**Minsmere Levels Stakeholders Group,
Stop Sizewell C and
Theberton and Eastbridge Parish Council
Issue Specific Hearing 7 (Parts 1 & 2)
Oral Contribution by Cllr. Paul Collins**

Biodiversity and Ecology

i. the SSSI crossing

DRAWING NO:
SZC-SZ0100-XX-000-DRW-100205

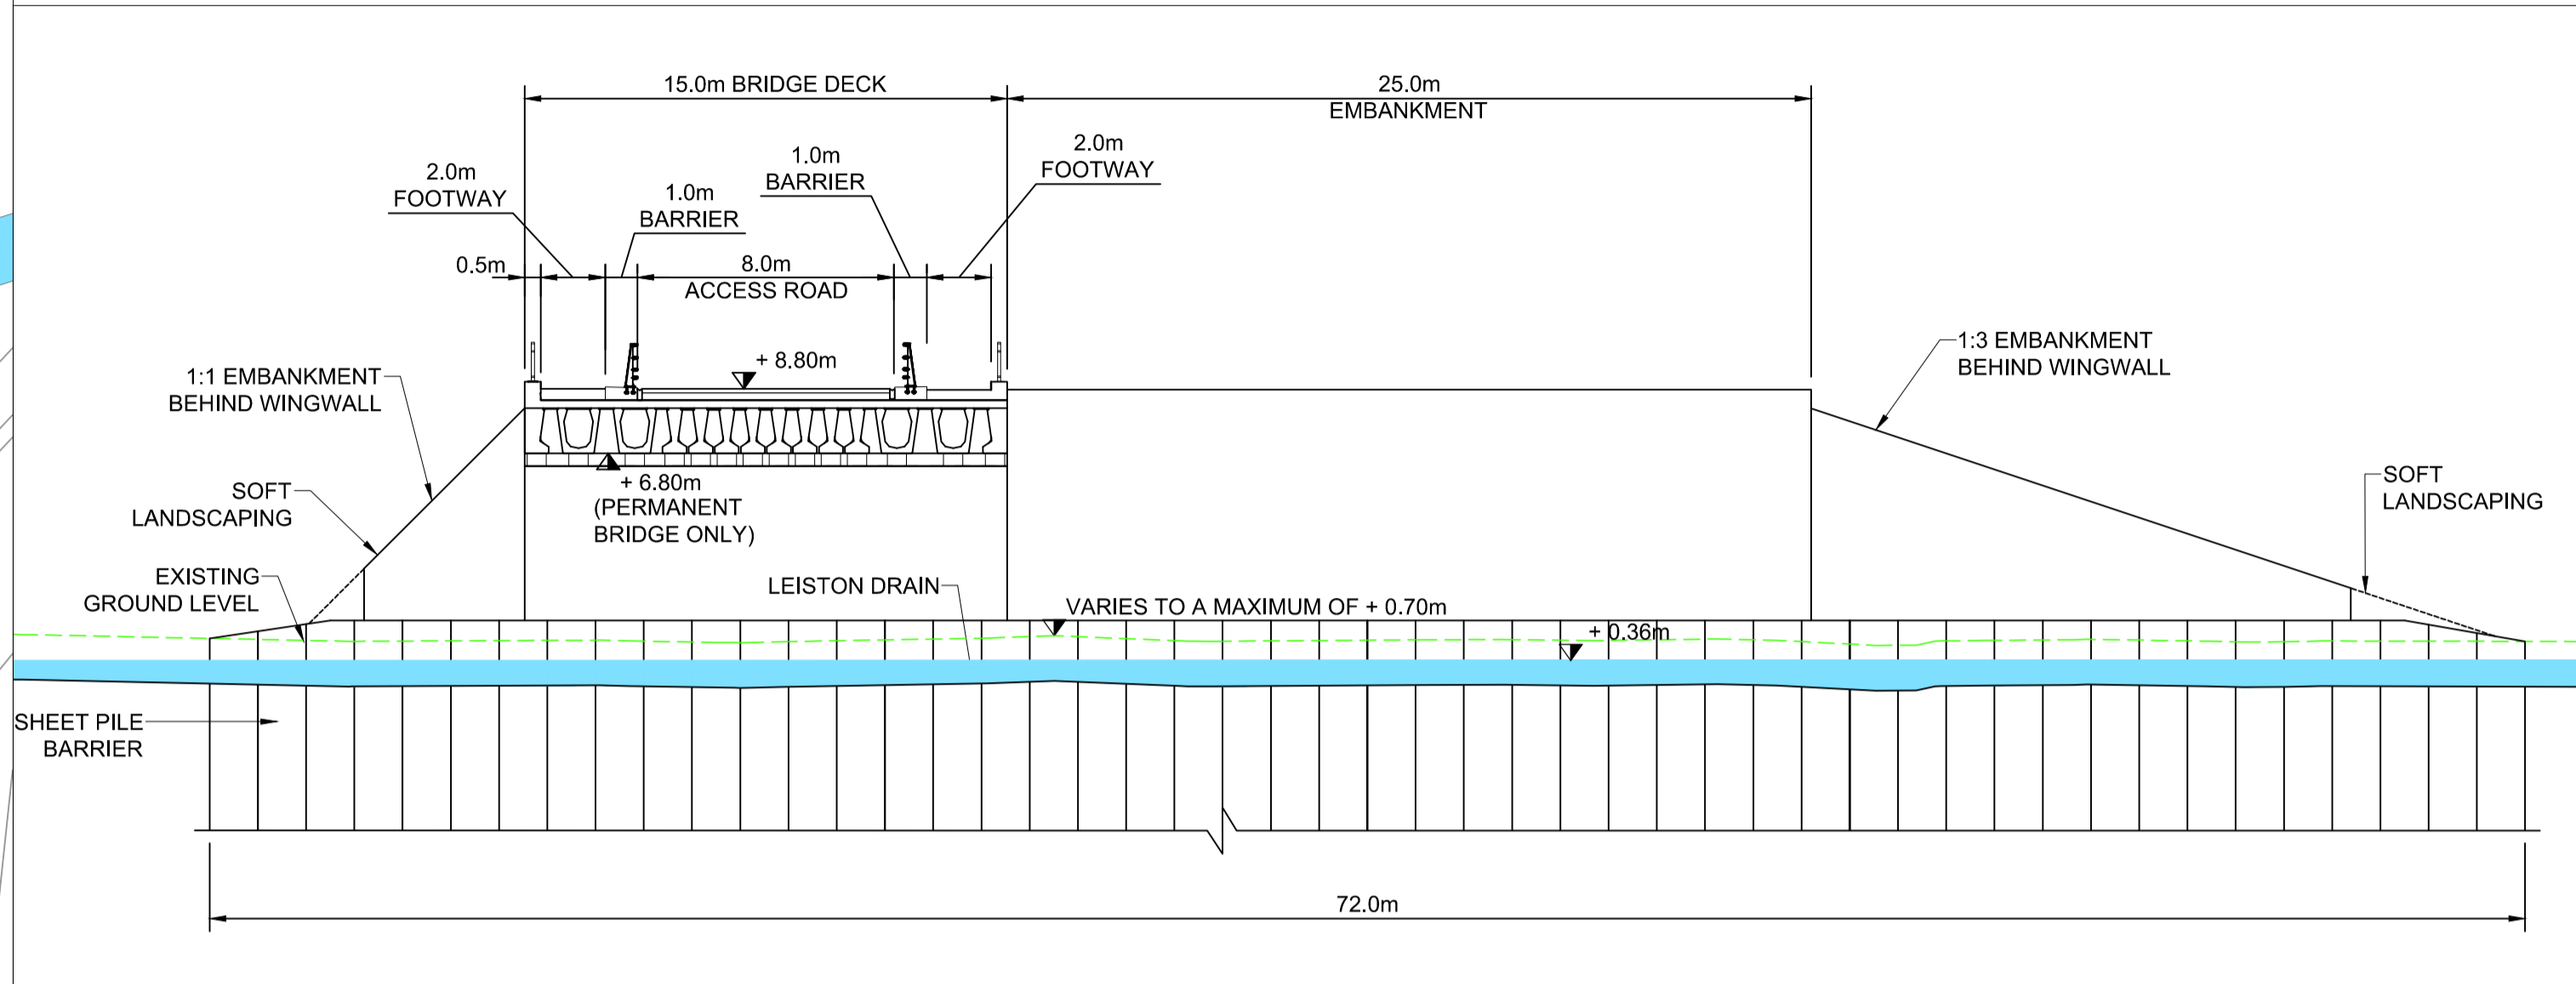
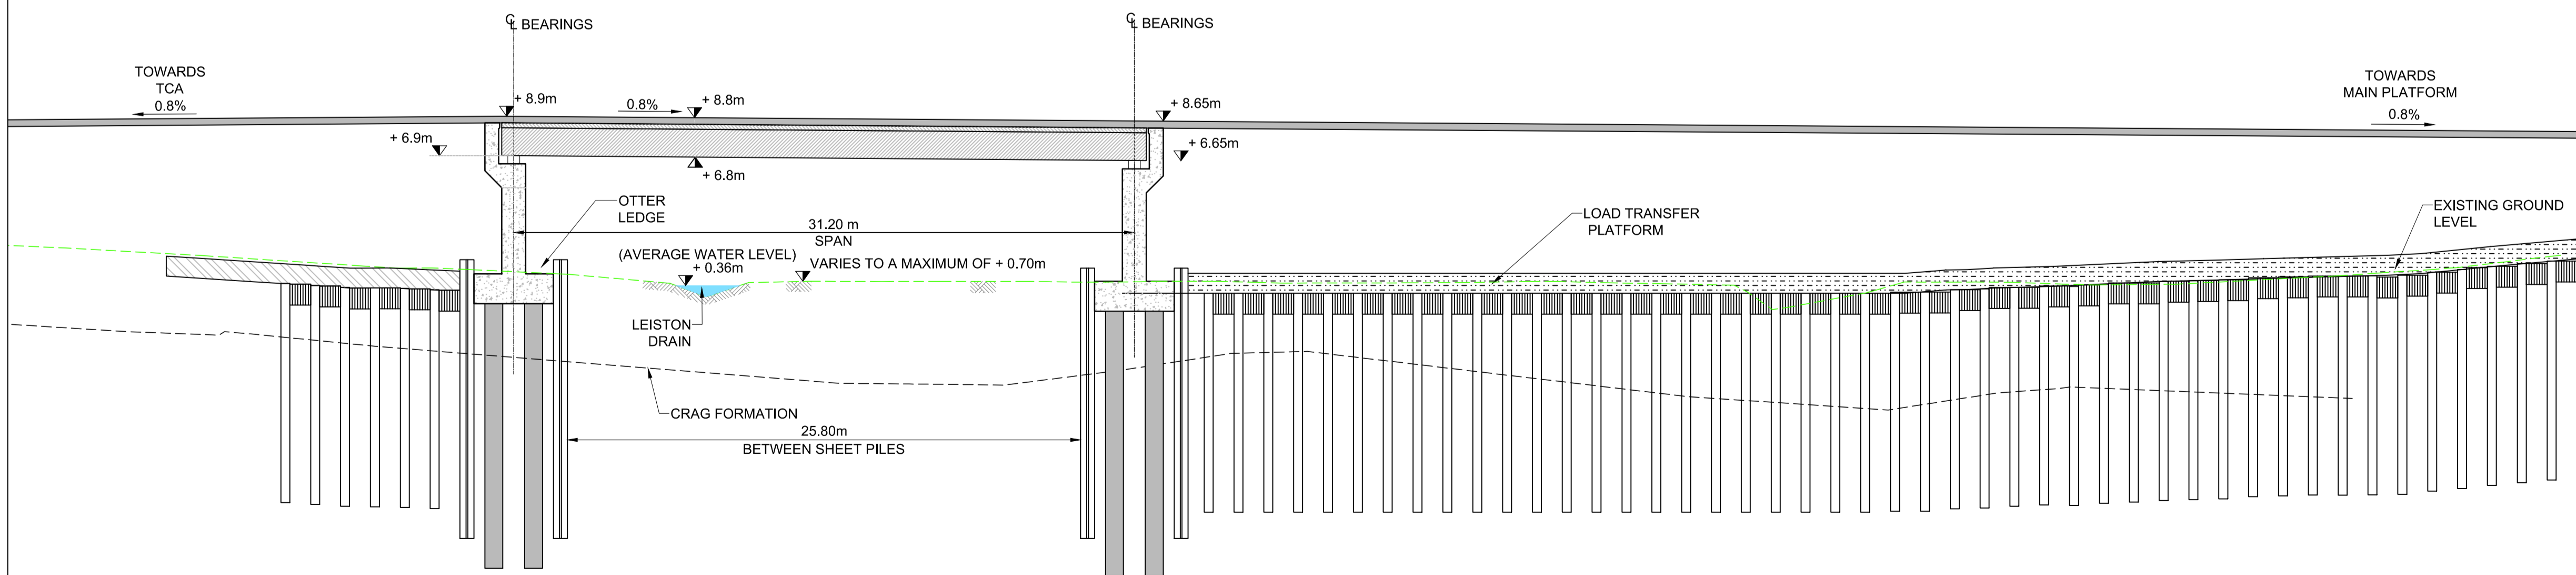
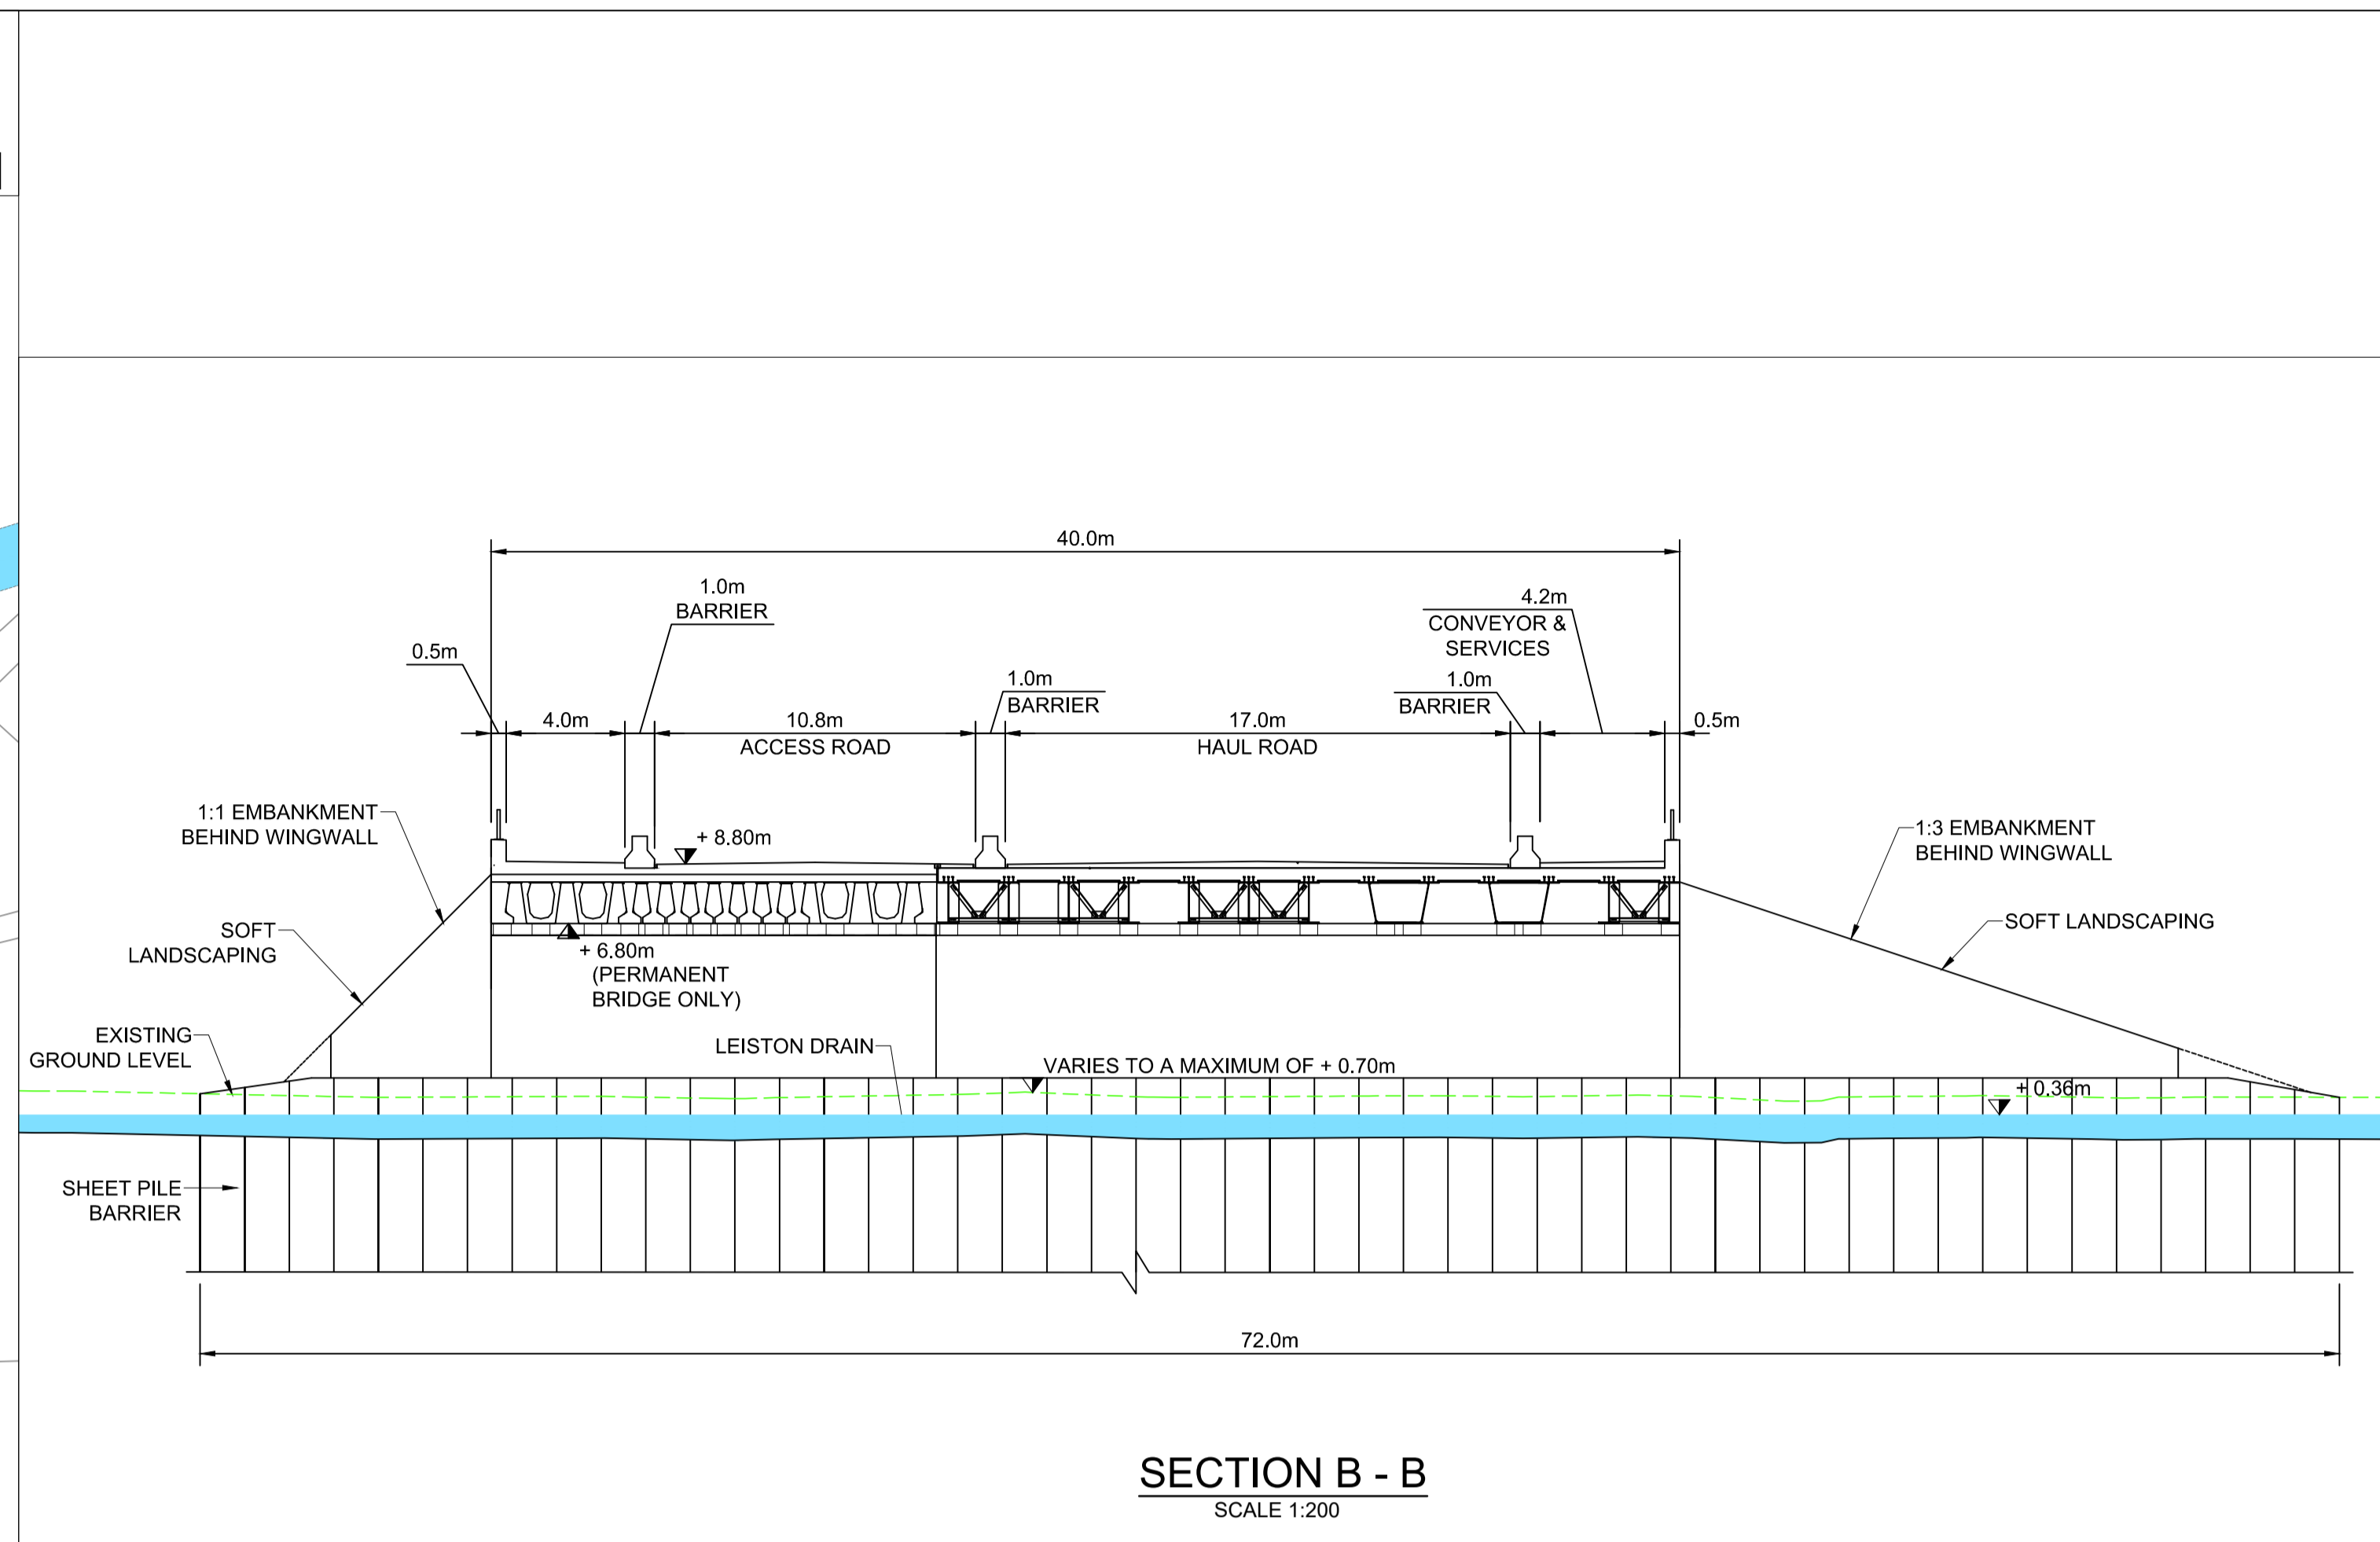
- I would echo what the previous speakers have said about the three-span bridge, we've always felt that that was the most appropriate option for a bridge across the SSSI. It has the least impact, and it would seem to have the least land take.

- The other issue that we have with the with the current design, and to an even bigger extent with the previous narrow culvert, is the fact that this is completely surrounded by sheet pile, and also then strengthened within it. The potential damage to groundwater movement through that part of the SSSI could be quite substantial.

- I know that some of the experts that we have been working with, through Suffolk Coastal Friends of the Earth, have said one of the things they were concerned about is not that water can get held up, it could actually speed up drainage beneath the culvert and start to dry out the SSSI.

- So that is the other concern that the groundwater effects are not as straightforward as they might seem to be. I would defer then to Dr Rob Lowe and Suffolk Coastal Friends of the Earth who lead on that particular set of assessments.
